North Lincolnshire Council

Planning Inspectorate's Reference: EN010148

Subject: Application for an Order Granting Development Consent for the Tween Bridge Solar Farm

DEADLINE 4 SUBMISSION

Figure 1: Proposed Area of Preservation in Situ

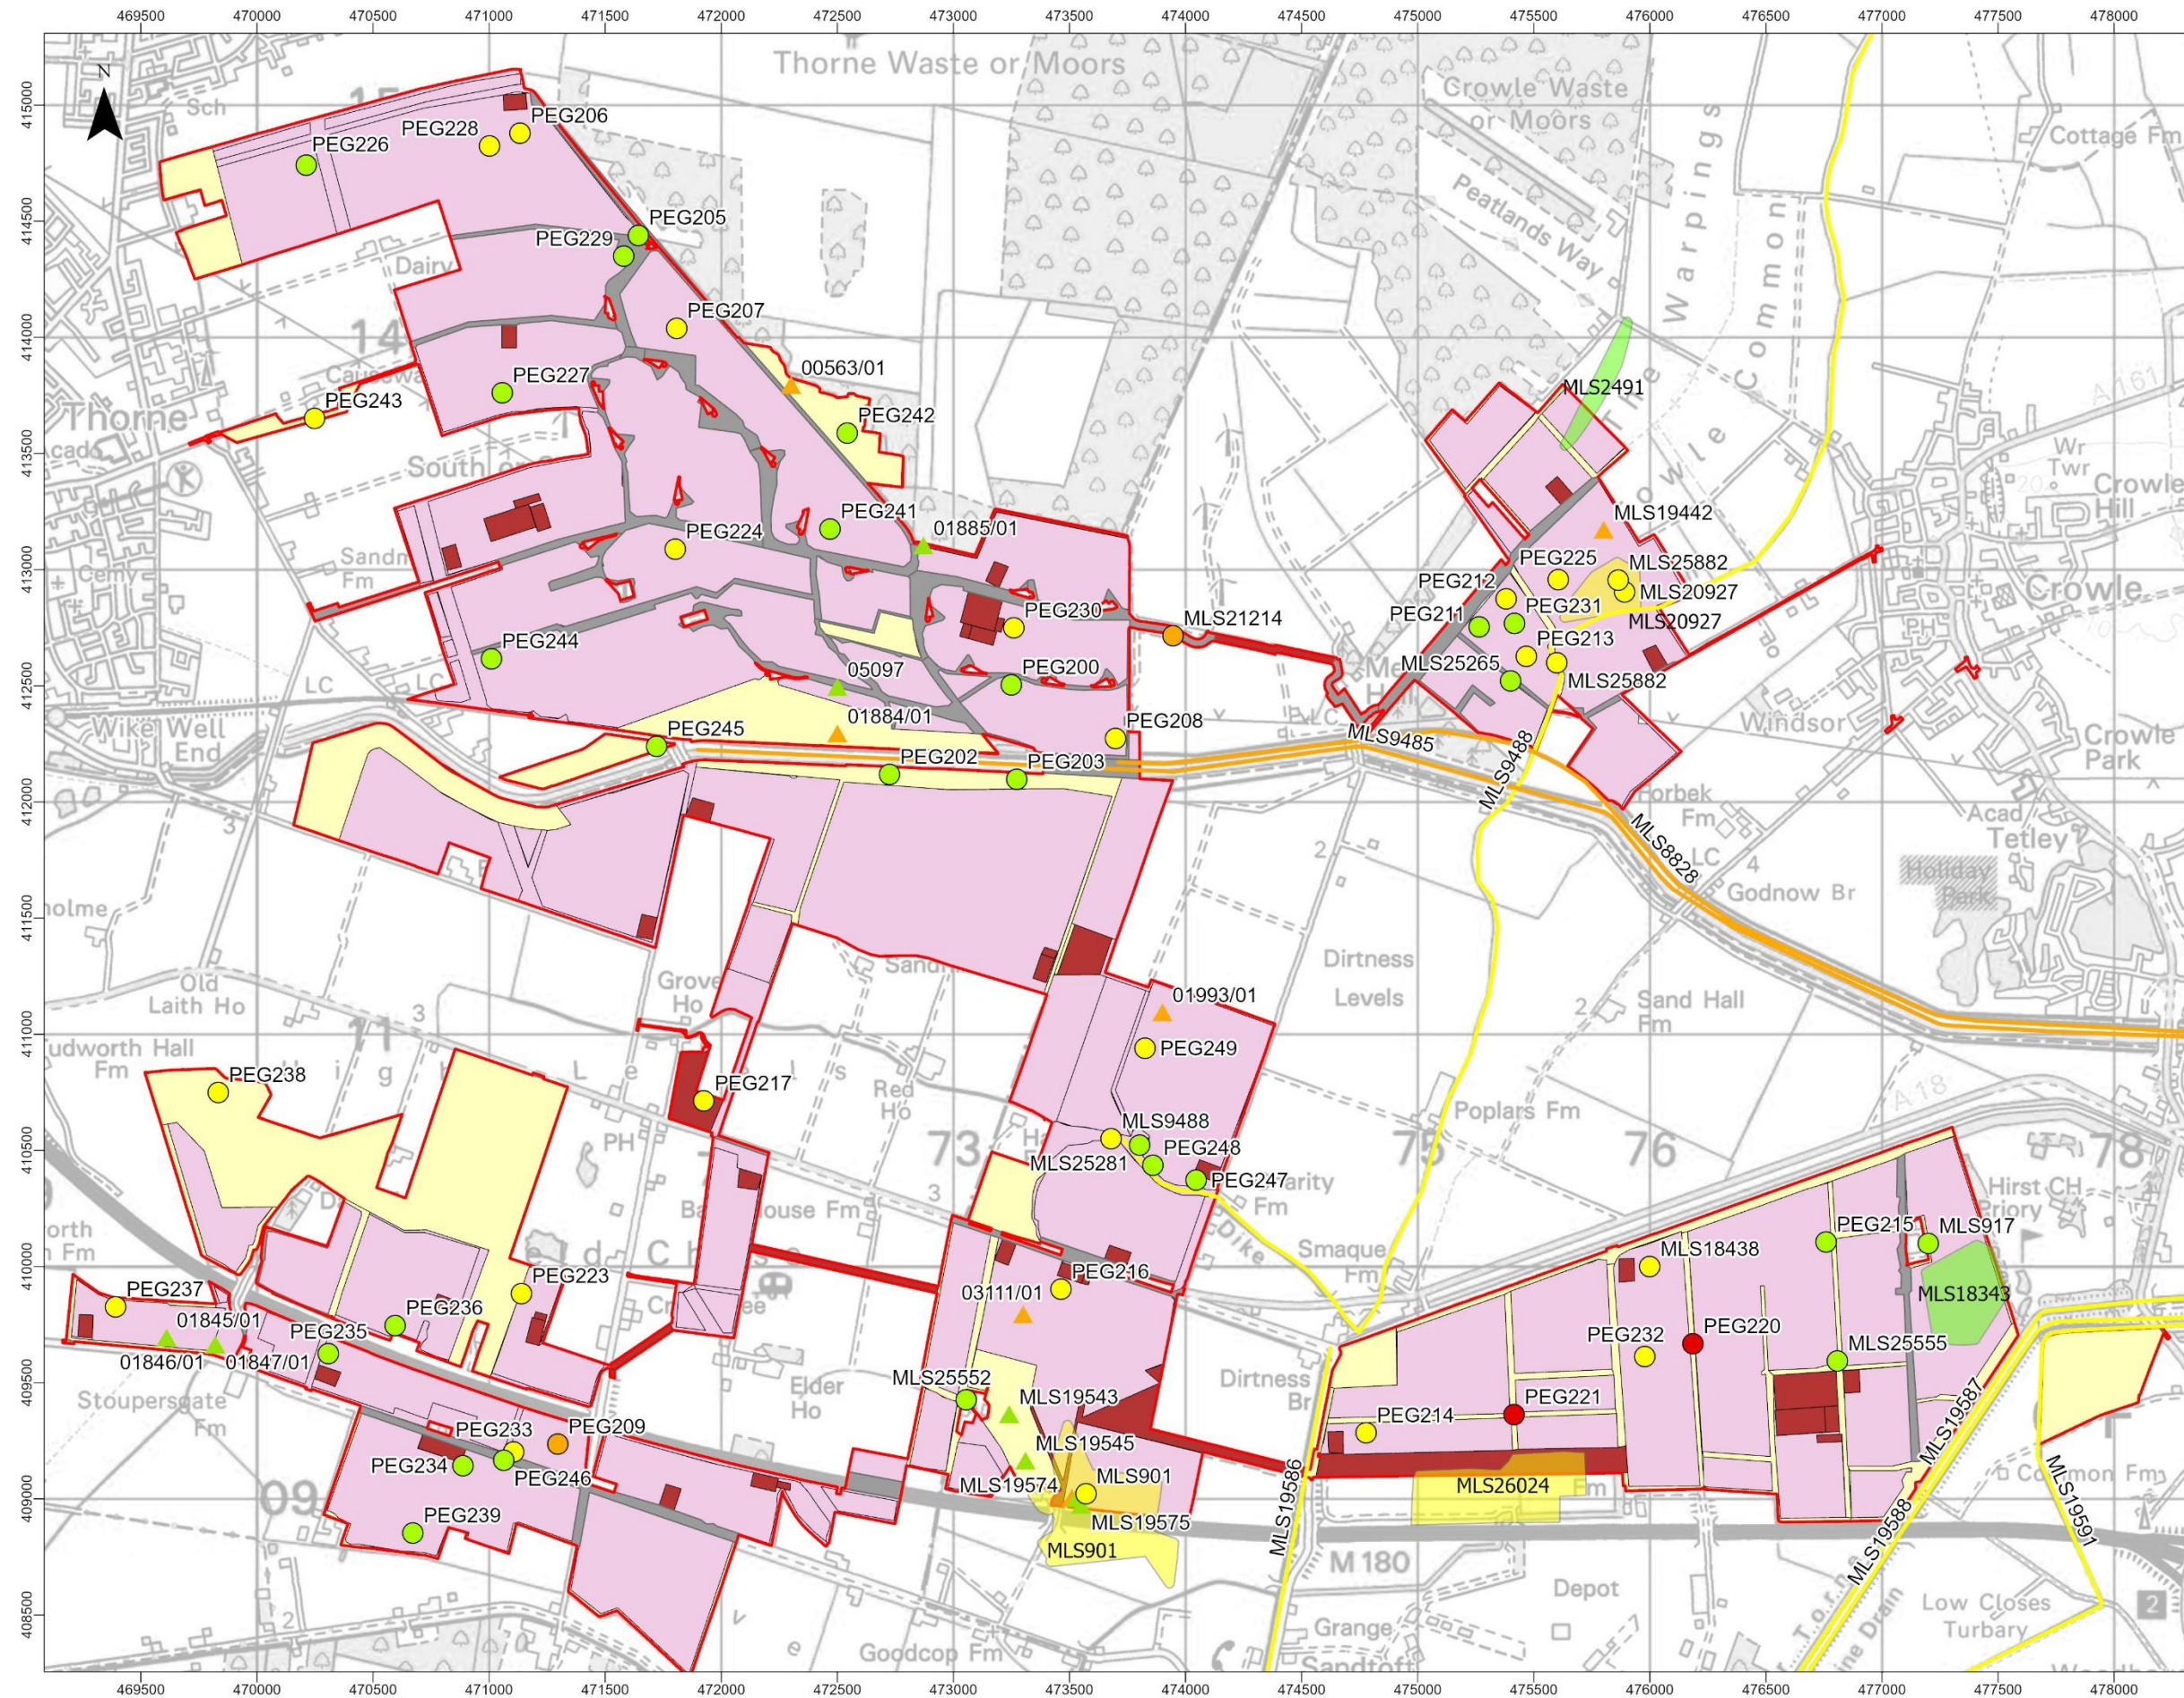
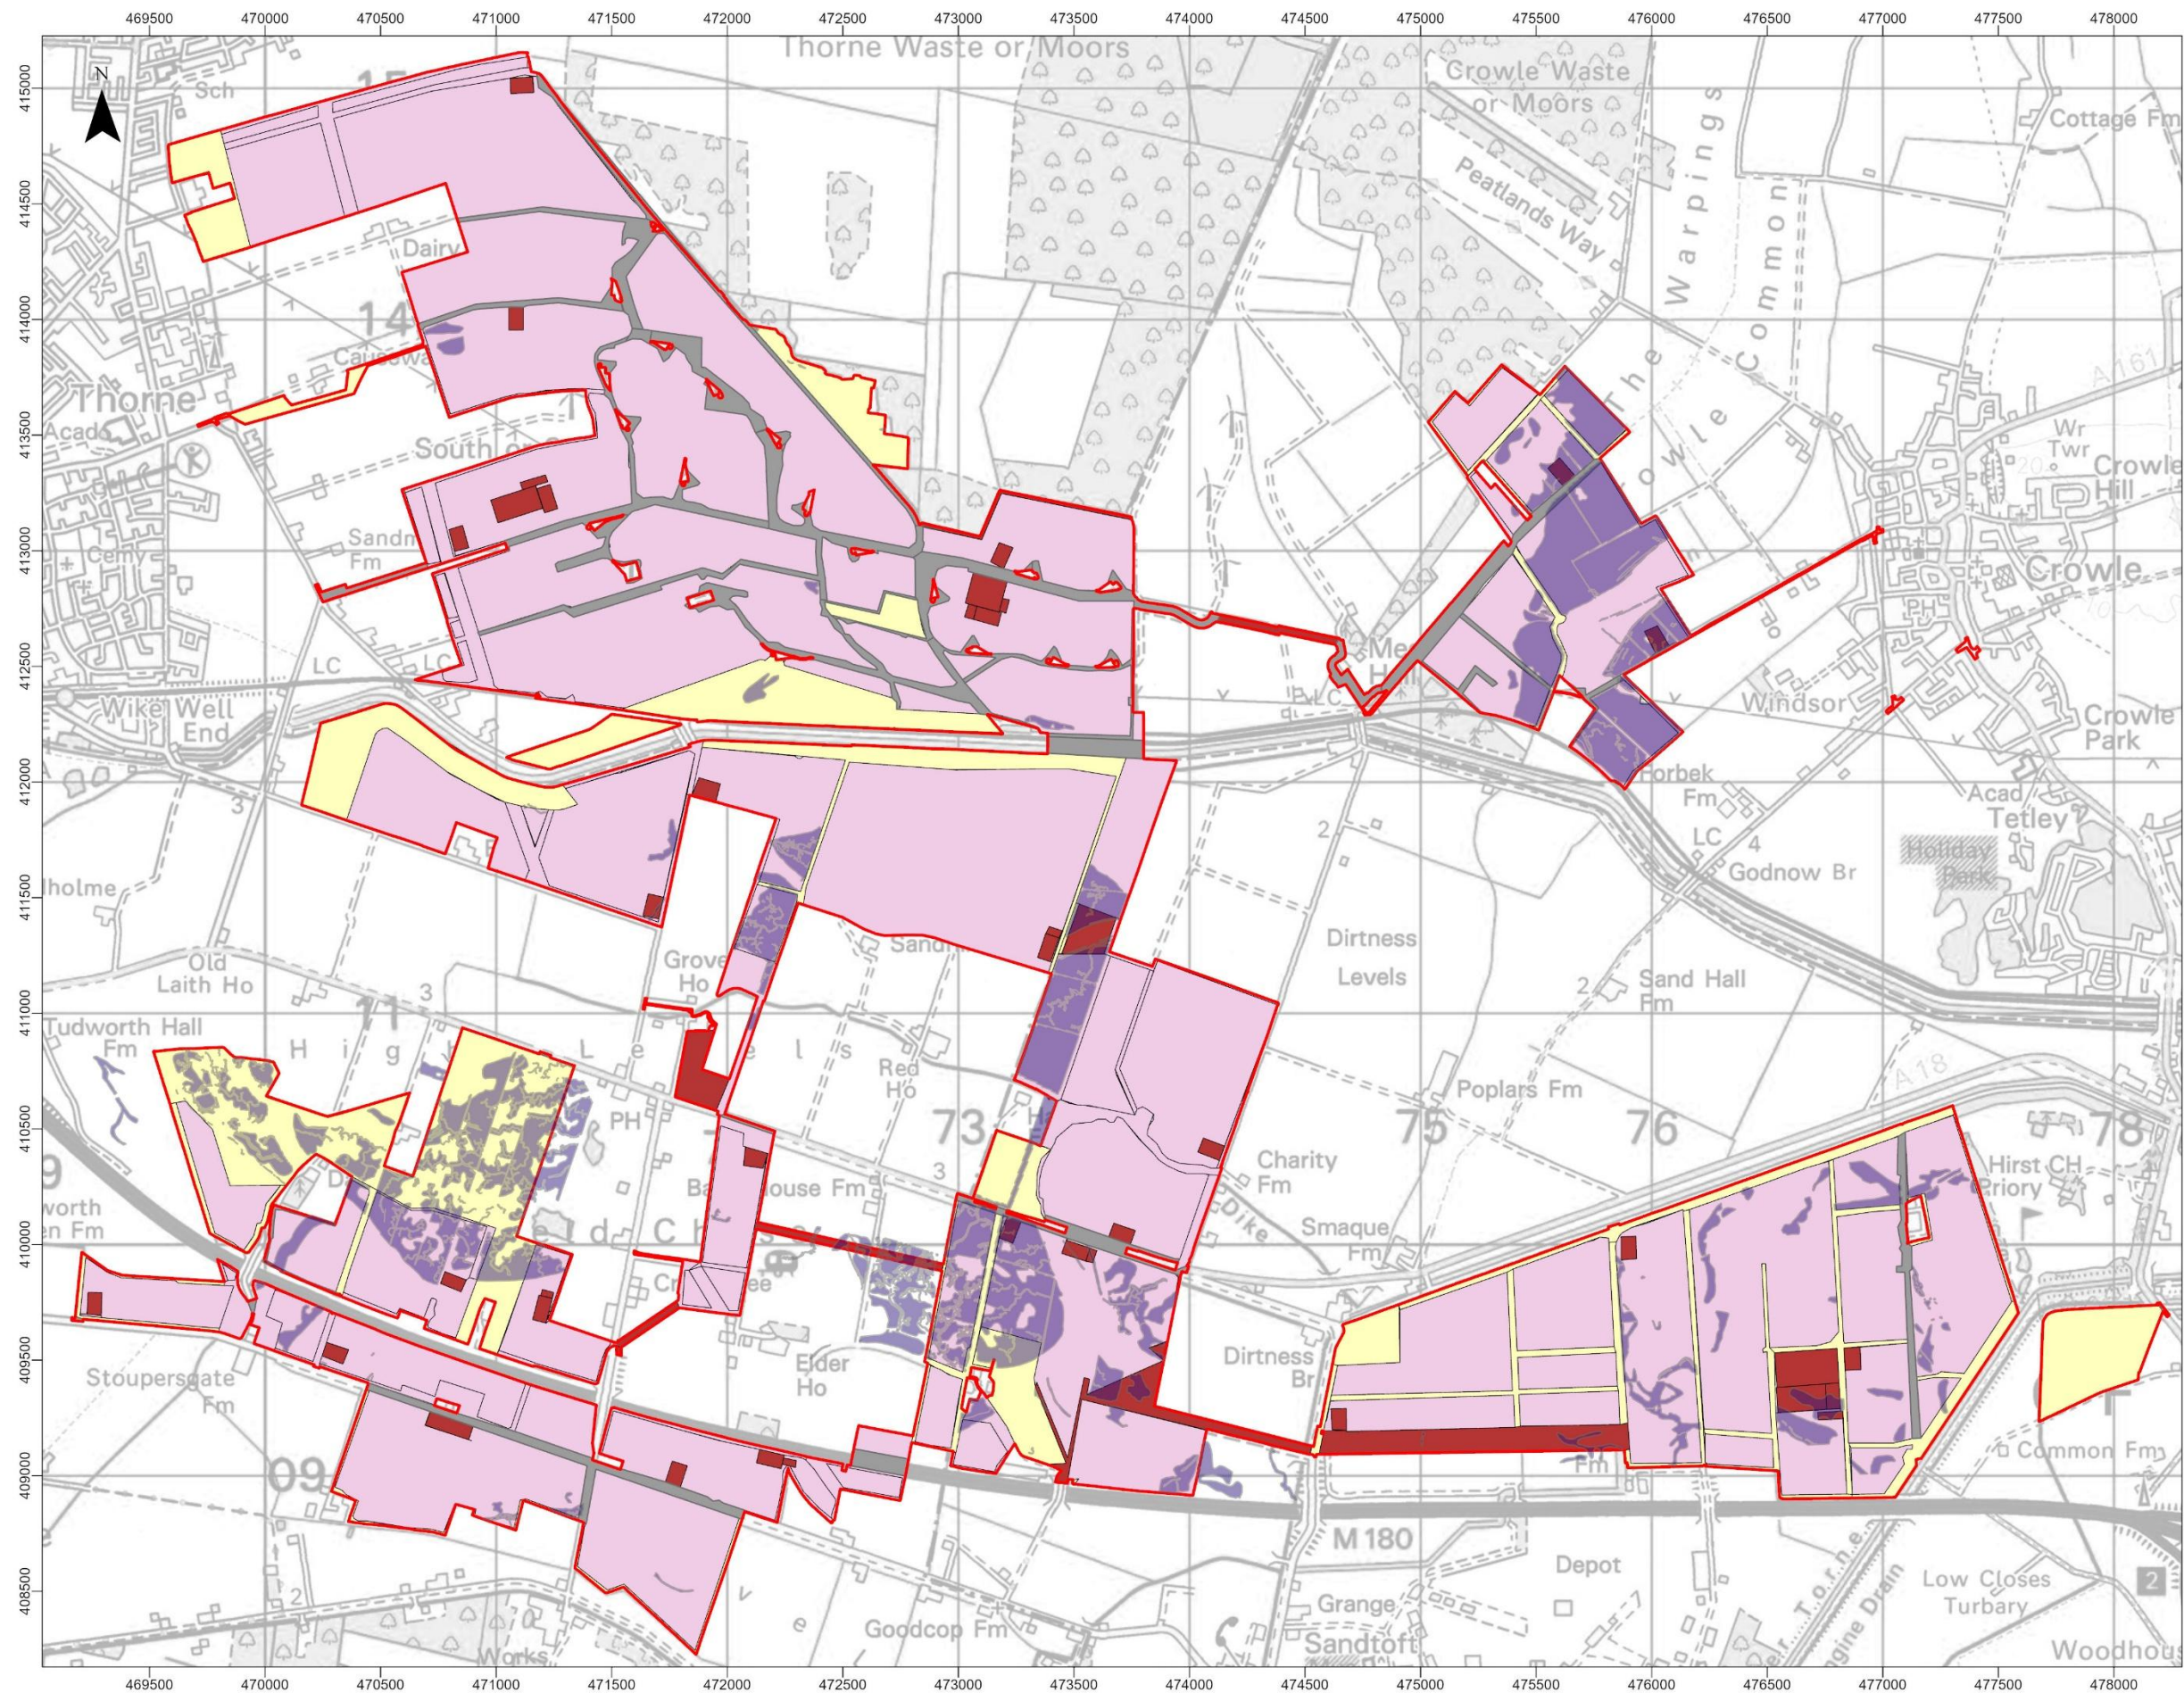
ExQ2	Question	NLC Response
		5. NLC agrees that the zones of sensitivity should be prepared on a worst-case scenario basis 6. NLC notes that CDC has agreed to provide examples of zoning plans received from other schemes as examples. 7. NLC notes that due to the complexity of finalising the revisions to the zoning plan the Applicant intends to issue it at Deadline 5, with the additional zones of sensitivity and a revised version of the oAMS using the currently available version issued at Deadline 4.
Q2.6.6	Dirtiness Pumping Station (Grade II) Paragraphs 12.28 to 12.30 of NLC's LIR [REP1-063] address the effect of the proposed development on Dirtiness pumping station. Could NLC please confirm whether it is suggesting 'less than substantial harm' would occur? Could the applicant also provide a response on this? Could the applicant and NLC update the ExA on any progress made in amending the proposed layout, as indicated at NLC LIR paragraph 12.30?	NLCs view is that the submitted layout would result in less than substantial harm, but not 'at the lower end' as suggested by the Applicant. NLC notes that, in response to the Council's comments, the Applicant has considered the feasibility of increasing the extent of mitigation proposed in relation to Dirtiness Pumping Station and proposes to alter the scheme in this area to include a strip of land that allows glimpsed views of the asset when approaching along the road to the south-west. Subject to those amendments, NLC would conclude that, subject to the SoS's conclusions in respect of the weight to be afforded to the benefits of the scheme, that those benefits would outweigh any residual effects on the setting of the pumping station.
